Great North Road Solar and Biodiversity Park

Draft Statement of Common Ground with Nottinghamshire County Council

Document reference – EN010162/APP/8.1A

**Archaeology and Cultural Heritage
Study Area
Figure 11.1**

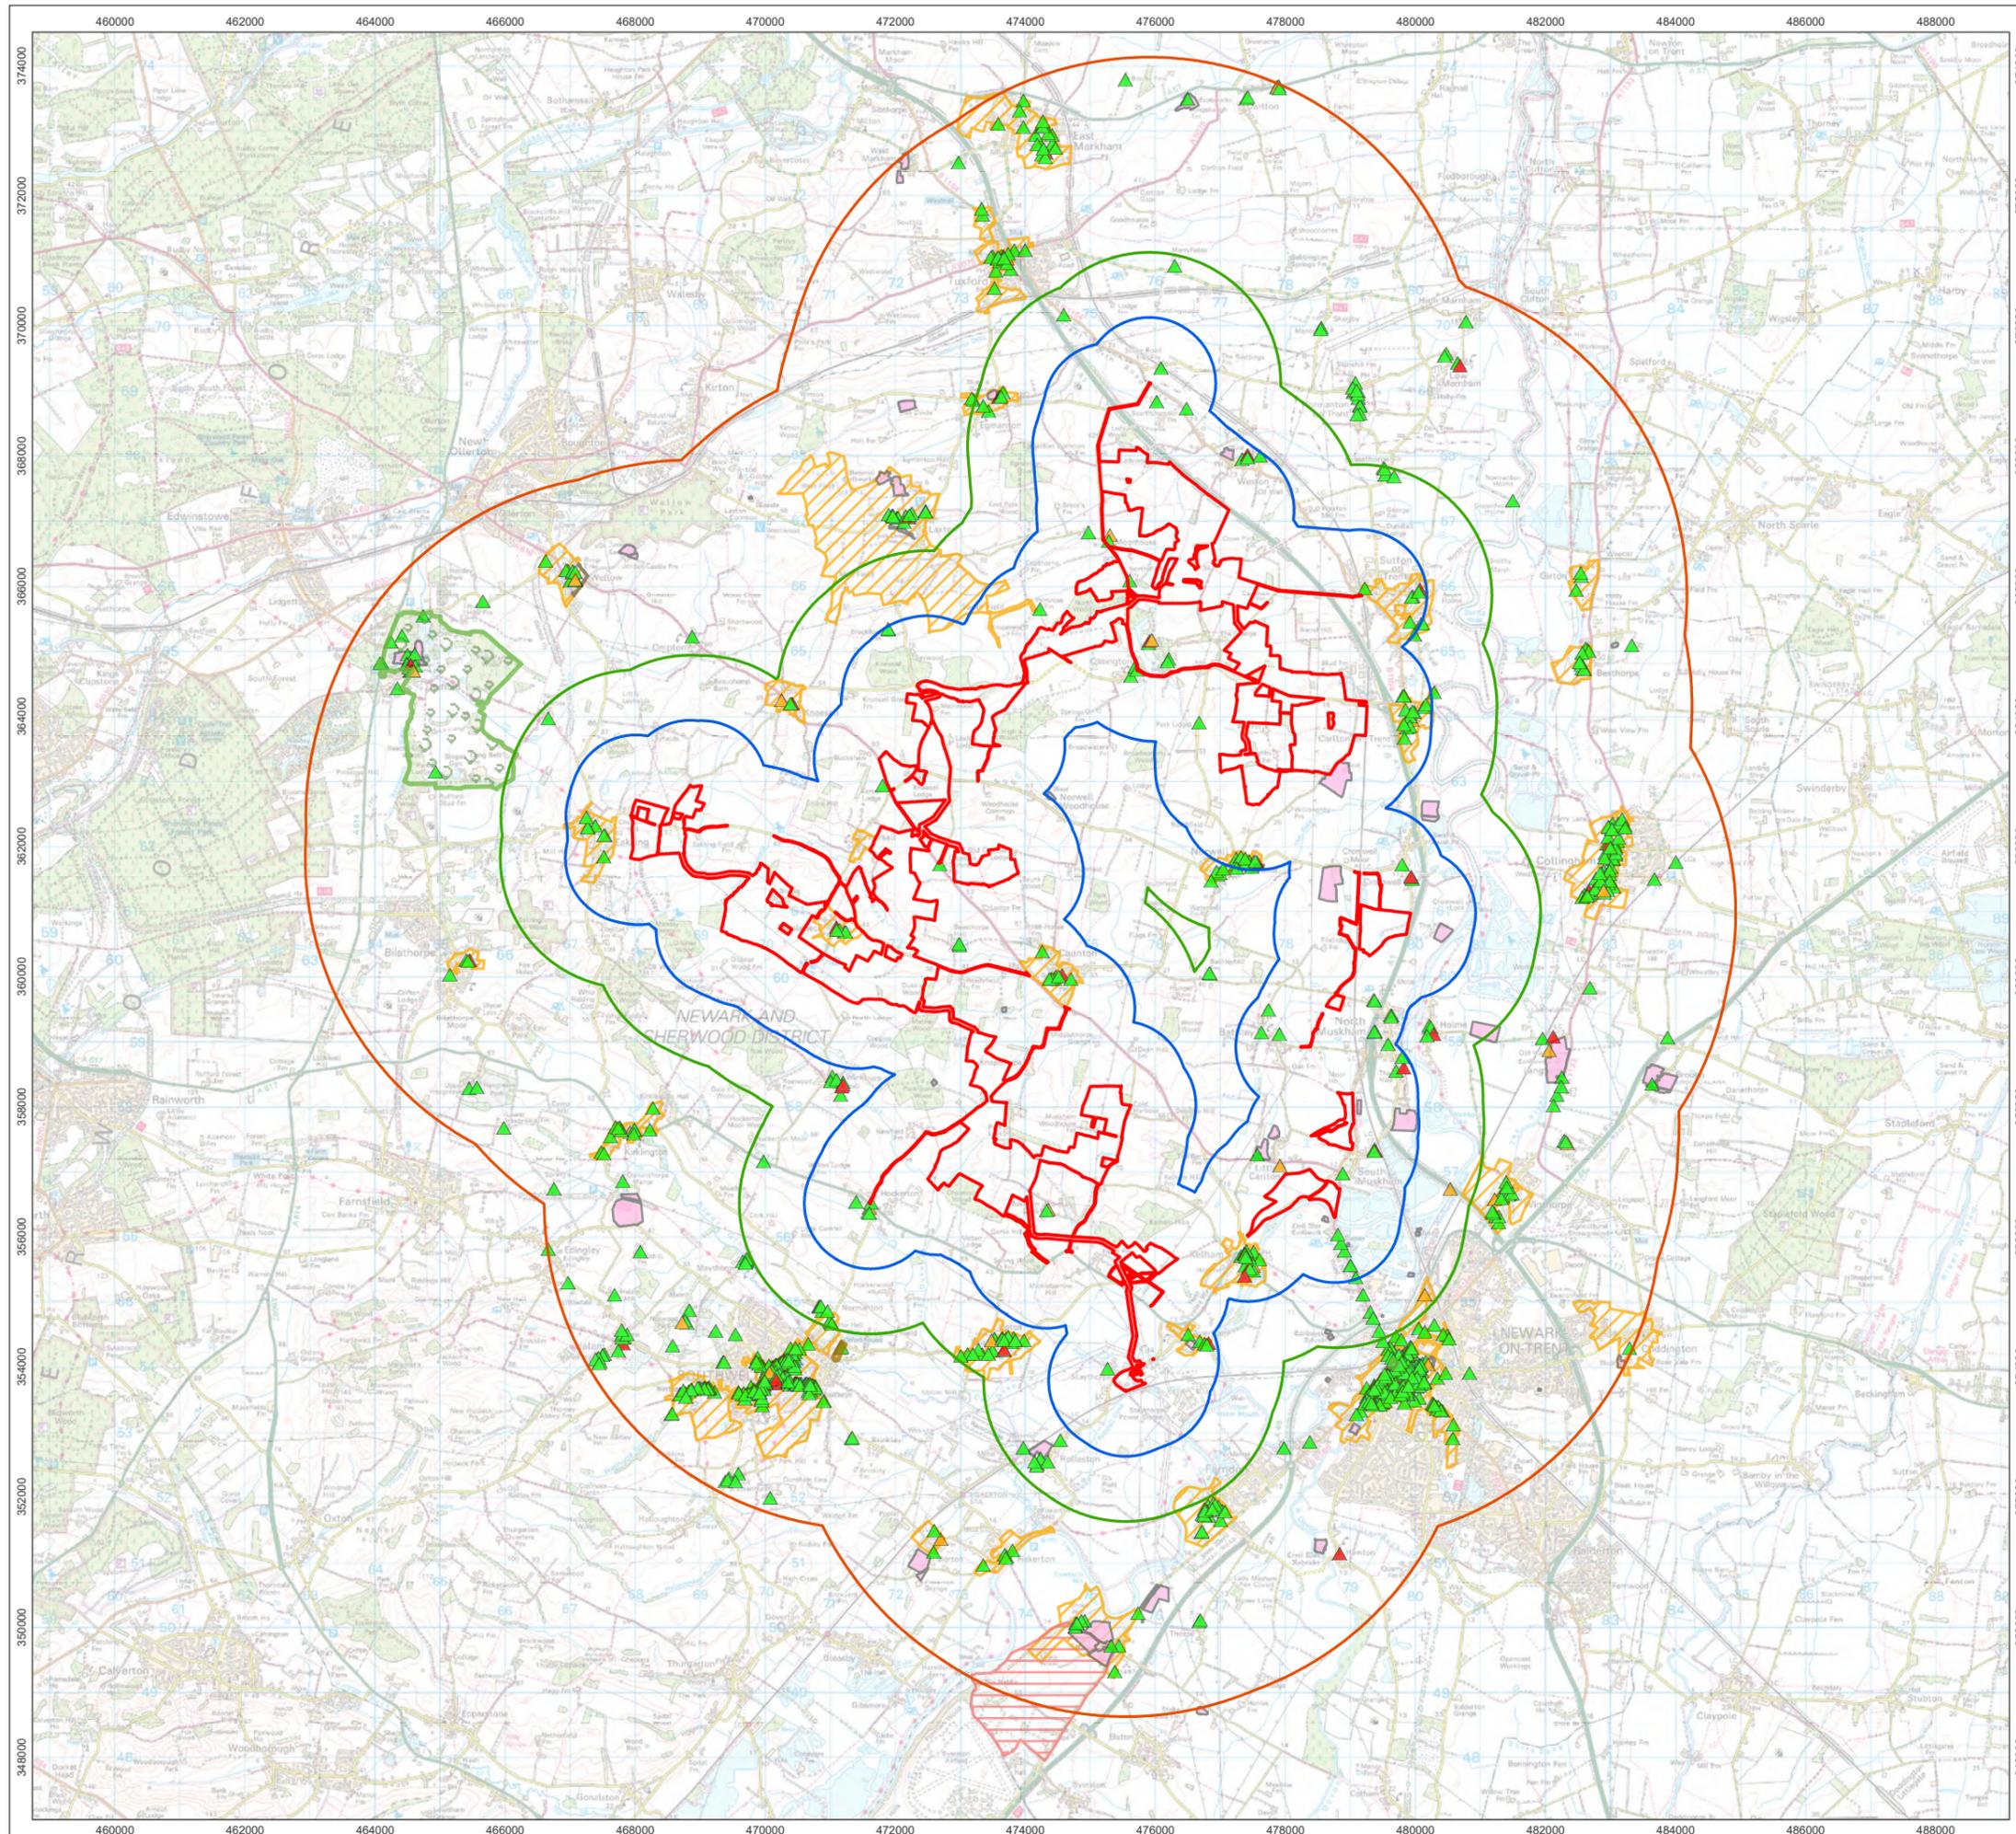
2.2.4	Section 42 Statutory Consultation in the Consultation Report	Scope of Cultural Heritage Assessment (Study Area for the Assessment)	The Parties agree that study area for the assessment is acceptable, and is presented in Section 11.4.2 the ES Volume 2, Chapter 11: Cultural Heritage and Archaeology [EN010162/APP/6.2.11] [APP-	Noted.	Agreed

Ref	Relevant Documents	Description of Matter	Applicant's Position	NCC's Position	Status
			054]. The study area map is provided in ES Volume 3, Figure 11.1: Archaeology and Cultural Heritage Study Area [EN0101/APP/6.3.11A] .
